Comments relating to planning Application 2023/91280

Date of Submission 18th December 2023

Figure B1: HDVs Haulage Route**Figure B2: Spatial modelling scope including verification site and the receptors**

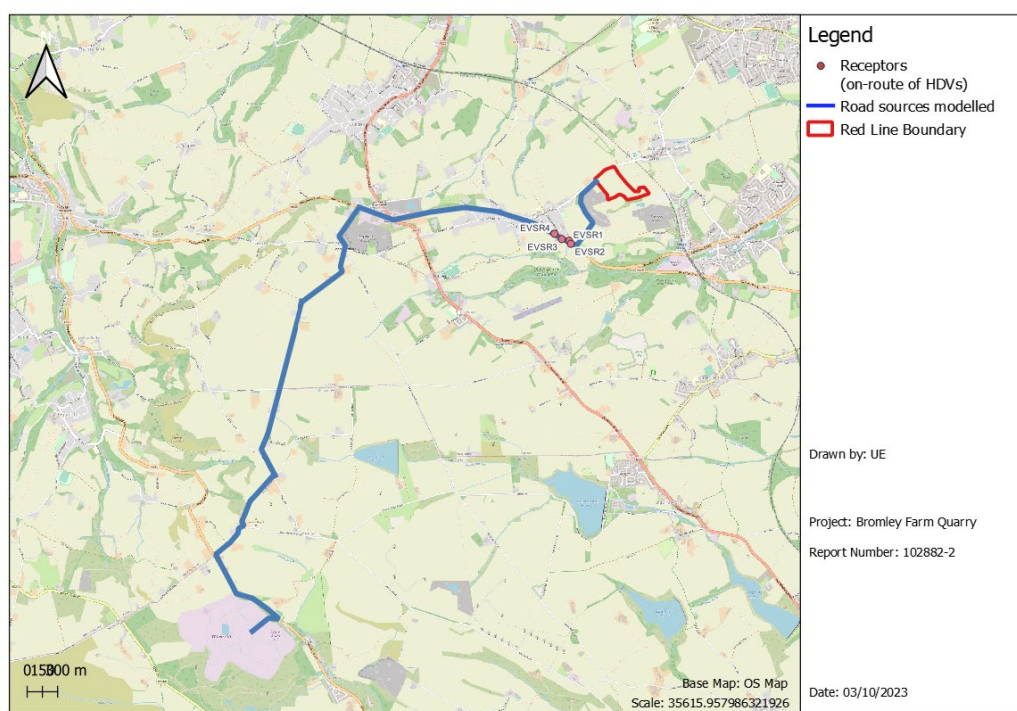
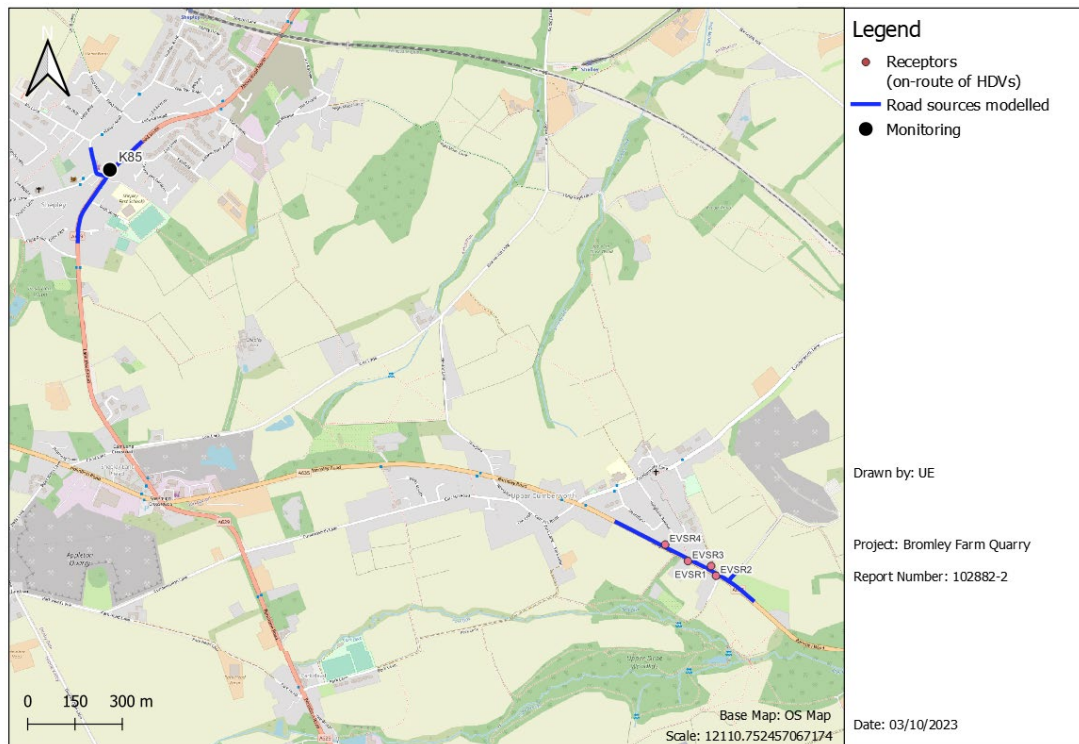
4. The HGV routing map

This document arrived after the other documents and set out a proposed route along the A635 , with a left turn on to Penistone road . The traffic and accident report does not extend to this part of the A635 , but if it did it would note that this is a well known accident site . The progression of an articulated HGV onto the A629 would require the driver to transgress onto the opposite carriageway . This is a busy highway , a staggered crossroads with the A629 , this is an issue which has been raised with the council since 2003 . Some traffic measures have been taken but the site still poses a significant hazard . Police advice to local residents is to avoid the crossroads at busy times , where queuing traffic comes back as far as Rowgate . None of this is factored into the traffic assessment and there is a serious risk to public safety.
